KIRKLEES METROPOLITAN COUNCIL INVESTMENT & REGENERATION SERVICE

DELEGATED DECISION TO DETERMINE APPLICATIONS FOR CONSENT, AGREEMENT OR APPROVAL REQUIRED BY CONDITION

Reference No:	2022/44/92236/E
Site Address:	Field House, 15 Wellington Street, Dewsbury, WF13 1BQ
Description:	Discharge of conditions 3 (windows), 4 (additional storey), 5 (materials), 6 (residential waste), 7 (A3 use waste), 9 (swift nesting), 14 (ventilation), 15 (noise assessment) and 19 (air quality) of previous permission 2019/92962 for erection of additional storey and conversion of building to provide 23 self-contained apartments and A3 use in basement and part of ground floor (Listed Building within a Conservation Area)
Recommending Officer:	Victor Grayson

Third Officer Report

4 Elevation 4
Scale: 1:100

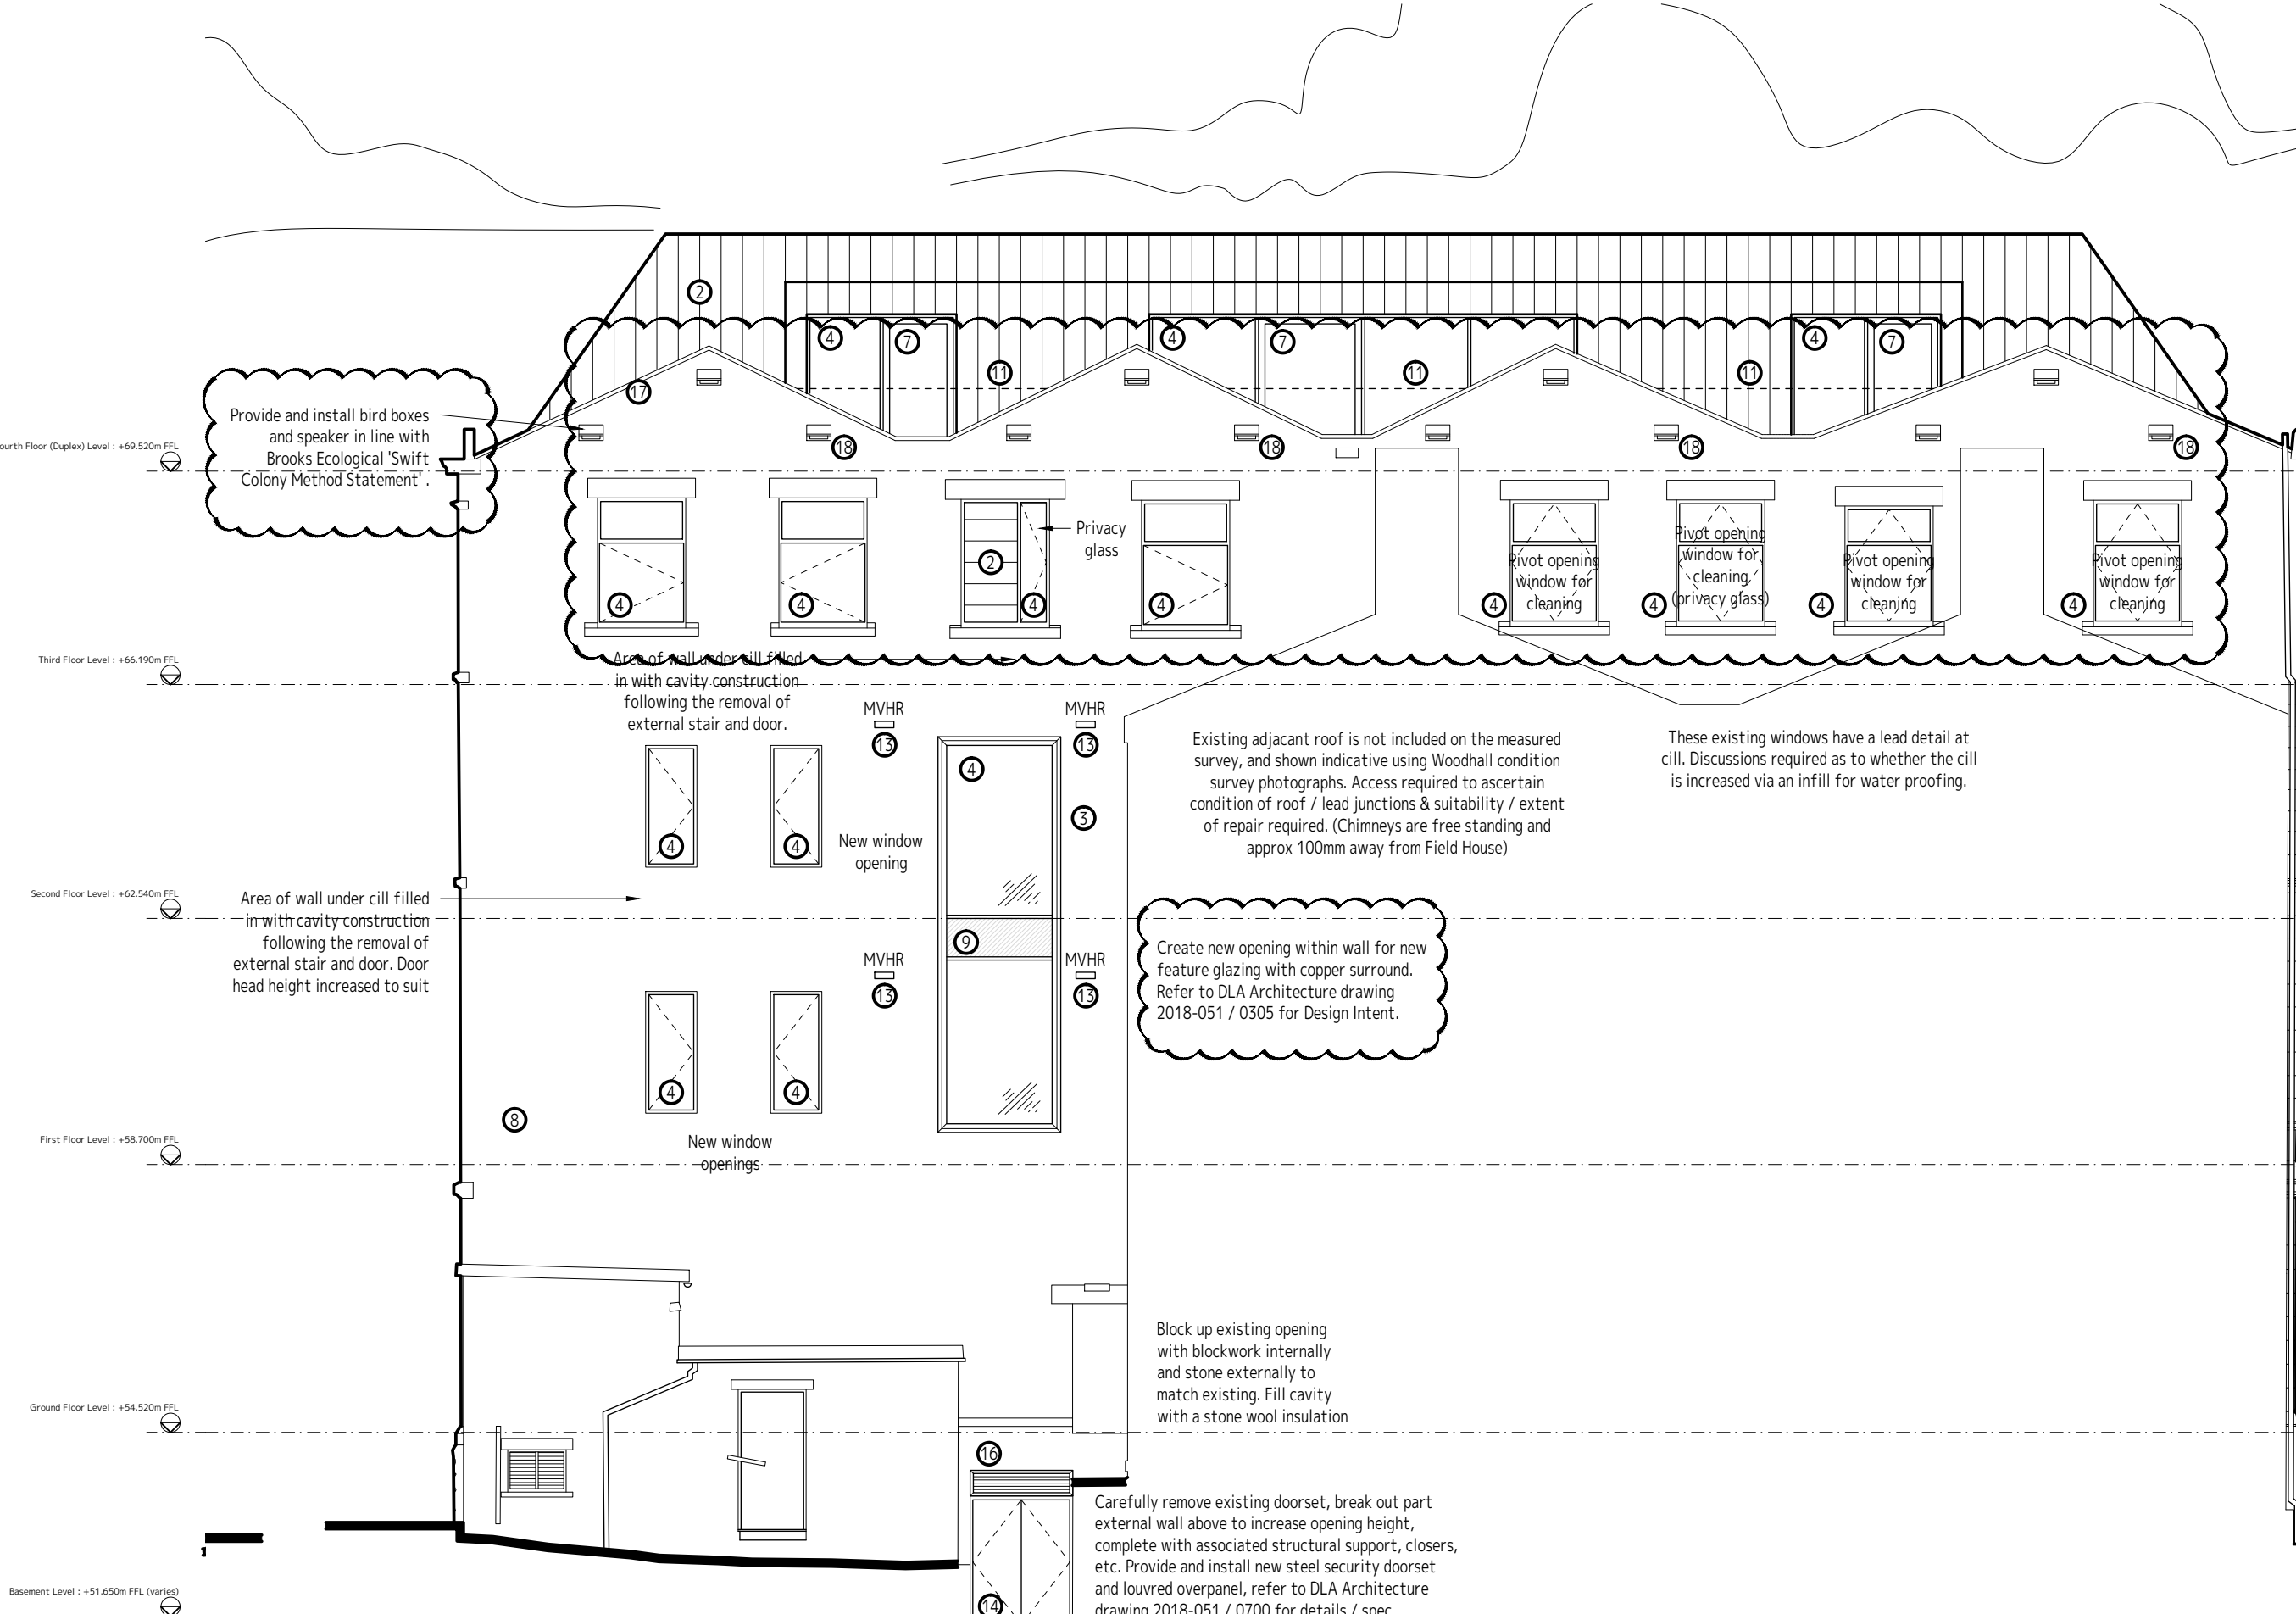
As proposed this additional storey could appear rather incongruous to the design/materials of the listed building and surrounding conservation area.

The window size looks reasonable but as [the case officer has] pointed out they are rather different otherwise. I am also uncertain about the complete lack of window surrounds when this is a prominent feature of the building, and the use of zinc cladding as the primary material on the facing pitches of the roof. Tiled materials/appearance for the face of the roof would probably be a better fit with the area.

Officers also requested amendments to the proposed replacement windows, including the deletion of pivot-opening windows at second and third floor, amendments to numbers of panes and to glazing bars, and the replacement of solid panels above the fourth floor windows with fixed clear-glazed panels. These amendments were made by the applicant.

During the life of this Discharge of Conditions application, much of the discussion with the applicant team has related to the proposed colour of the new windows. A dark grey (RAL 7021) is proposed for all windows with frames.

Officers' concerns related to context. Field House sits in the centre of a group of historic buildings (which have a shared character, and are the first thing seen when leaving the railway station opposite), all of which have white windows.

In comments dated 26/06/2023, KC Conservation and Design raised no objection to the design of the proposed additional storey, including in relation to its zinc standing seam cladding (although hanging slates would have been preferred), flush pivot windows to elevations 1, 2 and 3, and inset sliding doors on the less visible elevation 4. As detailed earlier in this report, a concern regarding the solid panels previously proposed above the fourth floor windows has been addressed by the applicant.

However, in the applicant team's most recent representation (an email dated 20/03/2024) reference was made to nearby buildings at Wellington Street and Whitehall Way, and to the applicant's desire to ensure the building's windows complement the additional storey and the entrance to the proposed A3 use. These points are valid. It is also noted that there is some evidence of dark-framed windows once existing at Field House. Finally, it is noted that the building's new timber windows would be painted, and could be repainted in future years should the current trend towards dark grey be reassessed. Taking all these considerations into account, while white or cream windows would still be preferable for this building (given its context, and as maintained by KC Conservation and Design), dark grey can be accepted.

01 Site Refuse Strategy Plan
Scale: 1:100

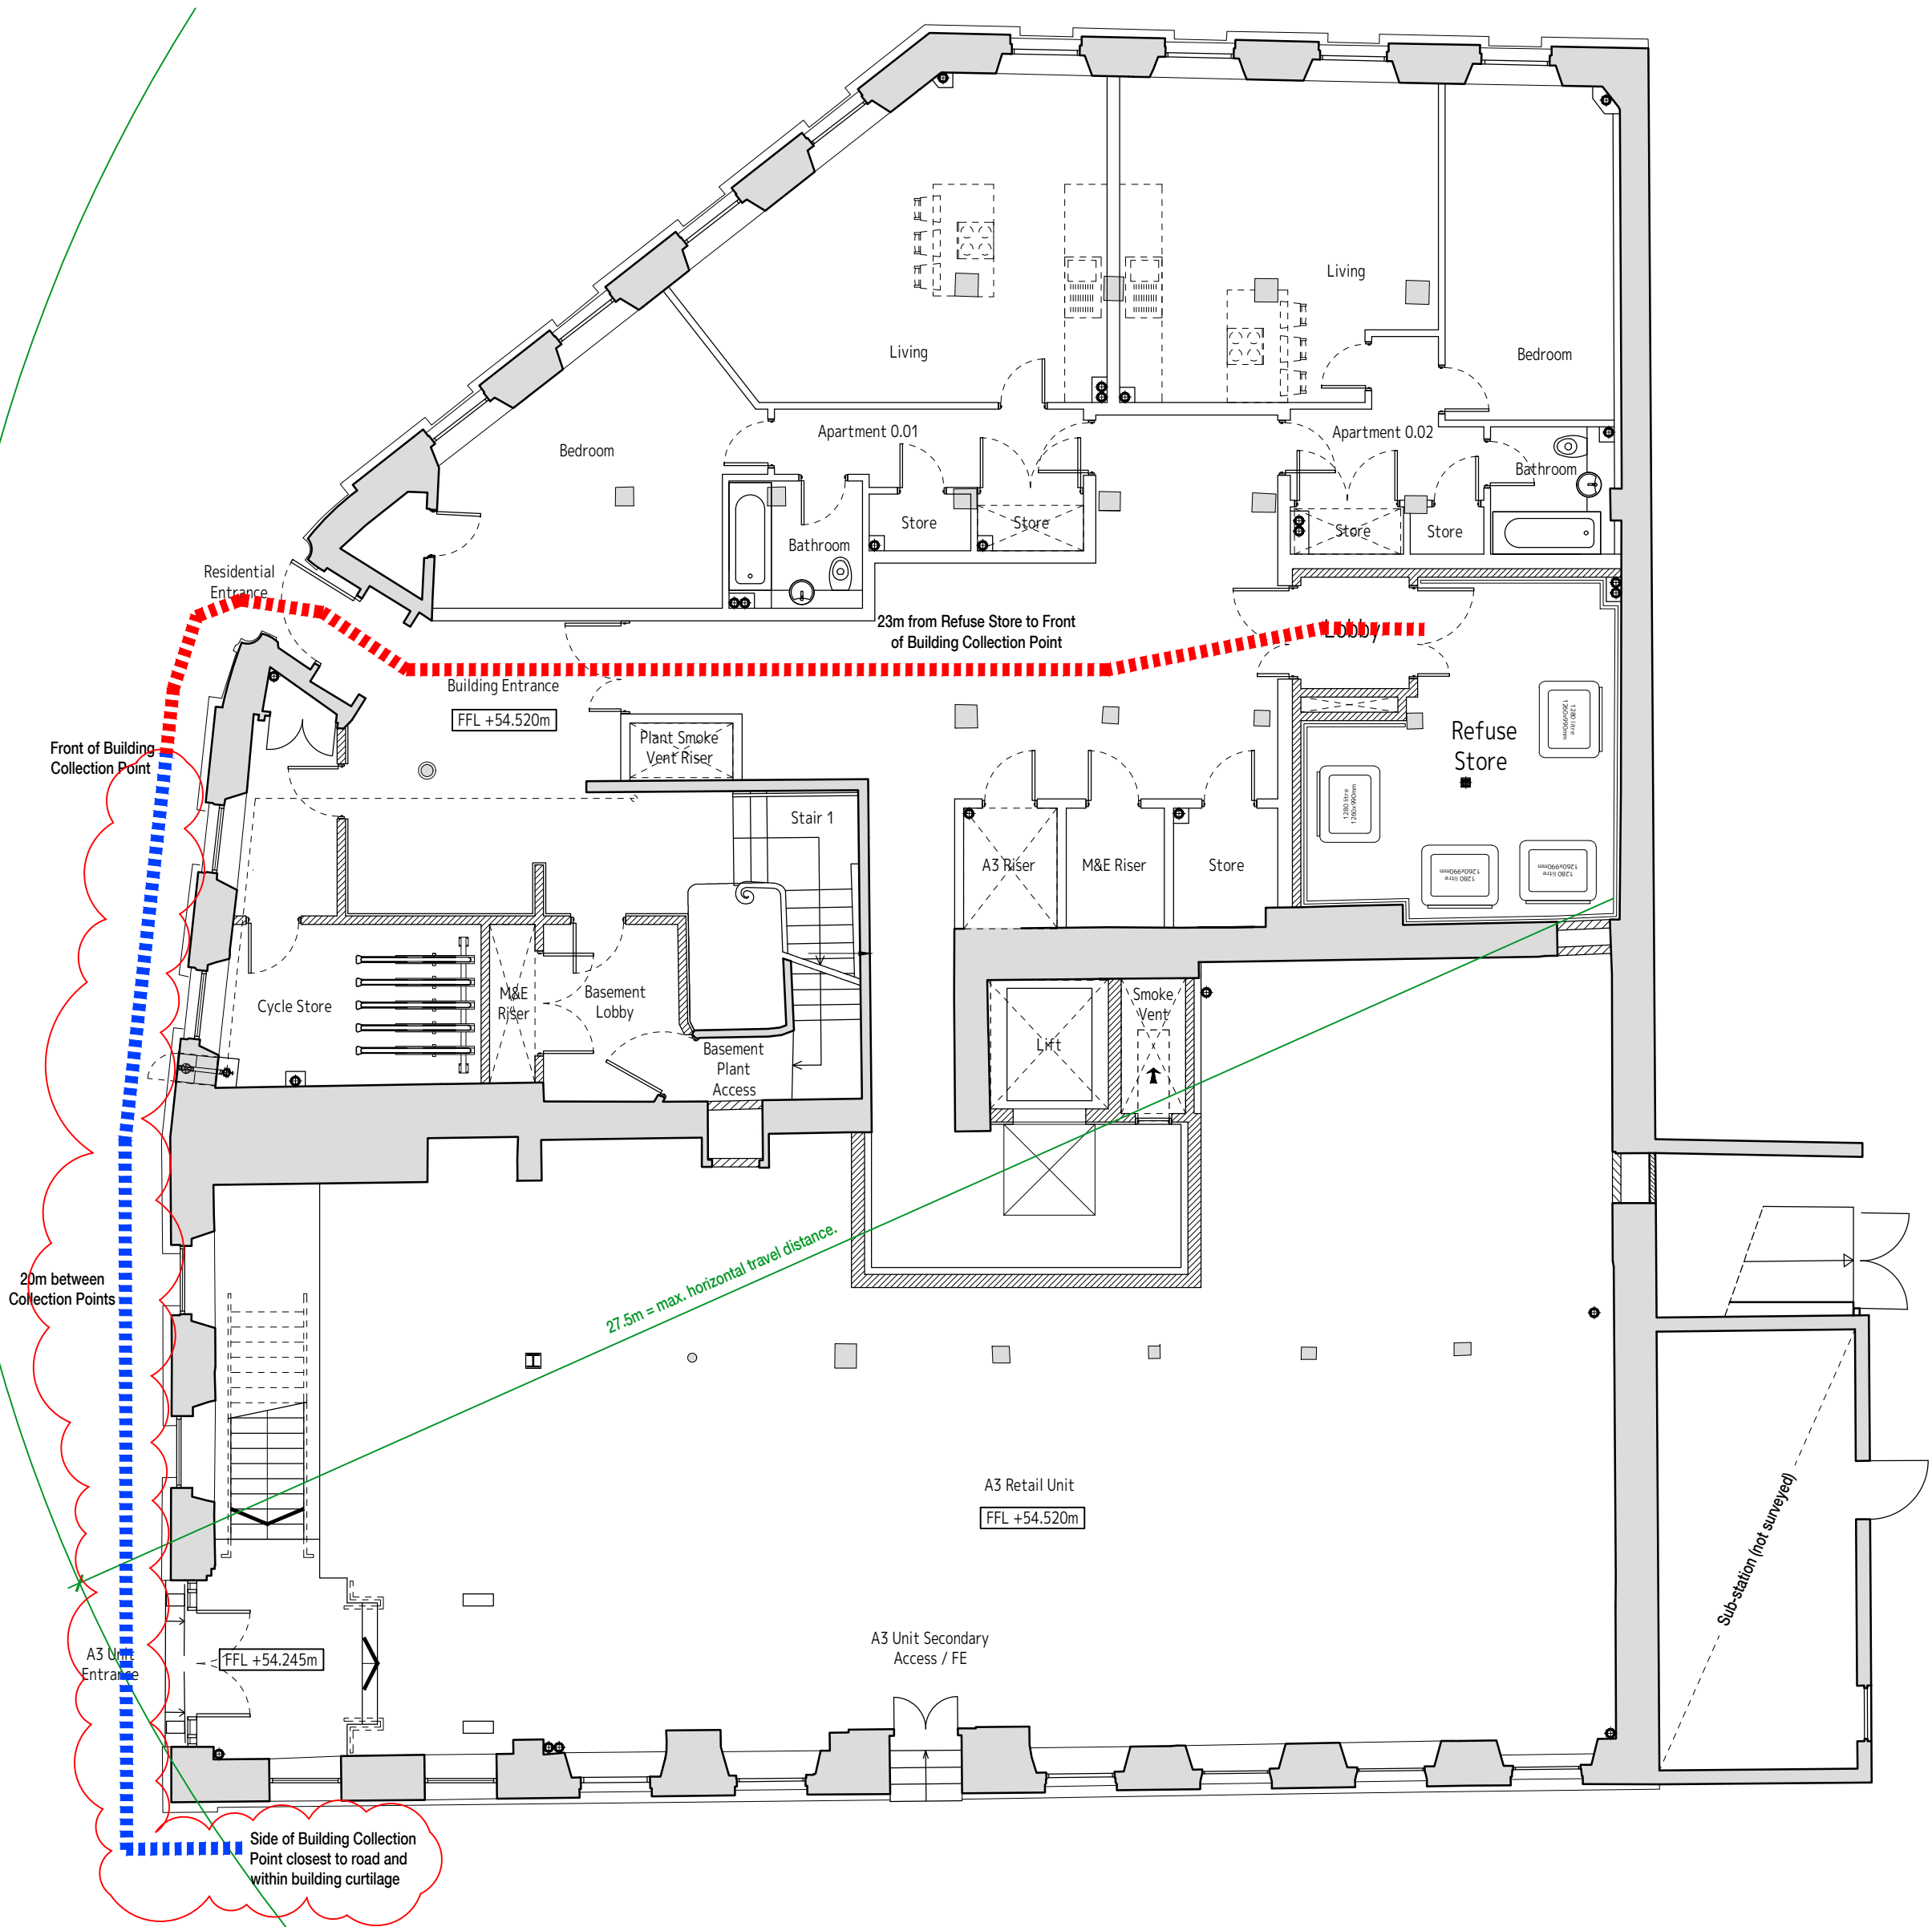
Despite some changes the proposals do not really address the waste issues identified by Carol Oakden in her response to the 2019 planning application e.g. location of store with access through lobby to main entrance and then no close location for access of an RCV.

The currently proposals include waste storage in the retail unit using a rear access door and ramp that with a change to the internal layout (depending on floor levels) may be a more acceptable solution for the whole building.

The new identified collection points to the side of the building will hopefully offer a more discreet location and ease collection as they are nearer to the road/kerbside.

We have marked the routes to the side of the building as additional to the original locations as they are now in excess of 25m but it is agreed they are a better location for collection.

It is also confirmed that the bins will be wheeled out to the agreed collection points and back again by the building management and the tenant for residential and A3 unit waste respectively on the day of collection.

I can confirm that the commitment for the management company / caretaker to be responsible for moving / putting out / returning bins from the internal bin store to a Bin Collection Point on the corner of Wellington Street at the location shown on the plans is acceptable and therefore the conditions can be discharged.
